About the application

Application number: 2024/90014	
What is the application for?:	Outline application for erection of residential development
Address of the site or building:	Land Adjacent, Binns Wood, Binns Lane, Holmfirth, HD9 3BJ
Postcode:	HD9 3BJ

Proposed Site Plan - 1:200

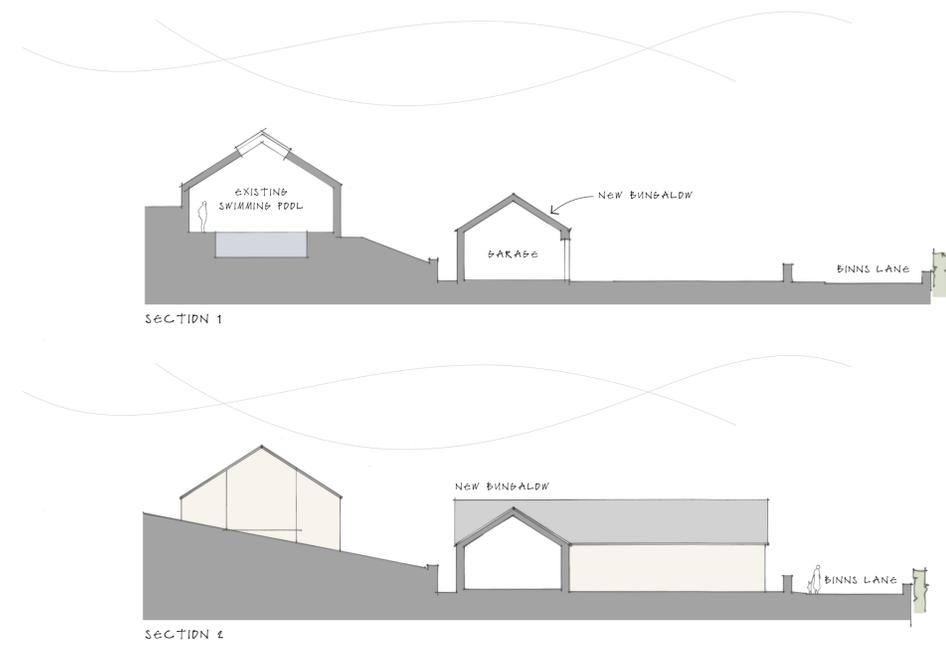
Type of comment: An objection	
Do you wish your comments to be published on the website anonymously?	Yes
I am concerned that the creation of tarmac or stone solid surface for Parking/turning area, as this will create additional "run off" of rain water onto South side of Binns Lane and into their driveways. This is a known problem currently as there are no road drains that currently exist anywhere along south side road on Binns Lane until about 100 meters from Cooper lane. It is a known problem for several households along Binns Lane for water to breach car entrances which then cascades down towards their house and garage. Using existing driveway for access by both houses may avoid this issue.
